Application for removal or variation of a condition following grant of  
planning permission. Town and Country Planning Act 1990.  
Planning (Listed Buildings and Conservation Areas) Act 1990

Demolition of an existing potting shed and covered sales area, to be replaced with a glasshouse and linking access to the existing Garden Kitchen. Construction of a two storey demonstration unit with offices and toilets. The construction of a covered terrace area adjacent to the Kitchen Garden. Construction of a training/classroom. Covered walkways

3/2018/0396

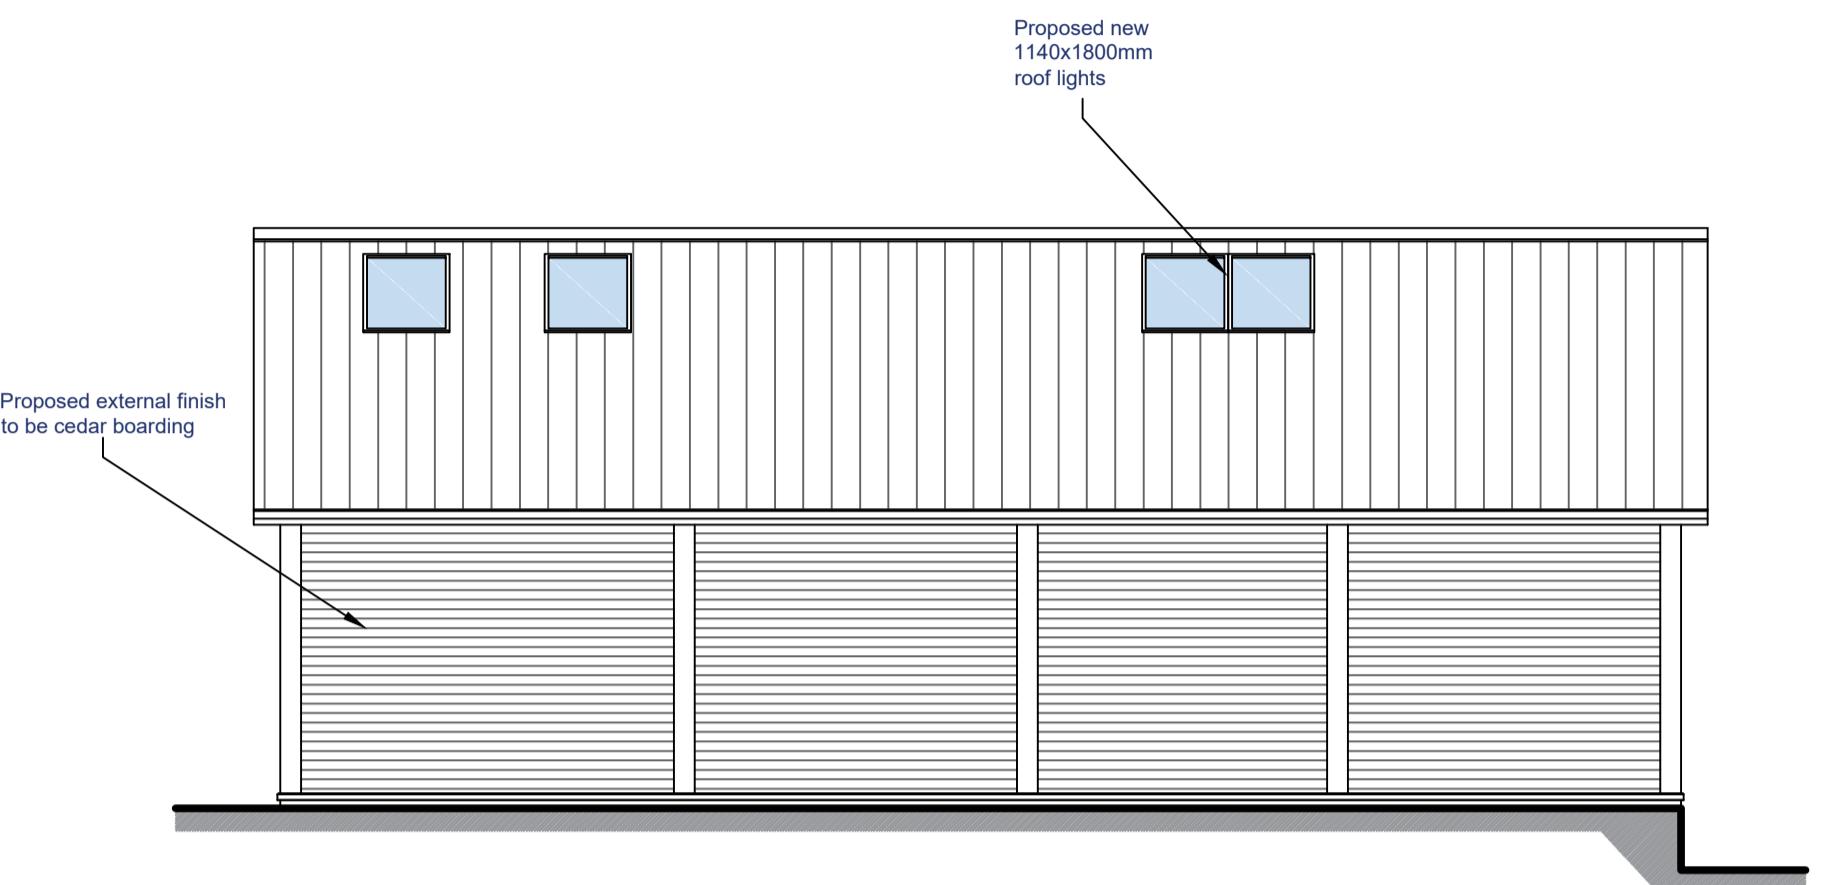
The condition relates to the materials used in the development. The proposed roofing material for the demonstration barn was originally a sedum living roof. During the preparation of calculations for the specification of the steel structure of the building a number of factors have come into play which make this material impractical. The pitch of the roof is steeper than recommended for sedum roofs and the additional cost is in excess of £120/m<sup>2</sup>. A decision has been made to alter the roofing material to a type which allows a more practical alternative, whilst maintaining the natural appearance of the roof.

The condition to allow the roofing material to be fibre cement sheets which will be treated to encourage lichens, liverworts and mosses to colonise the sheets to give a natural weathered appearance. A full description of the materials and methods used is laid out in a supporting statement.
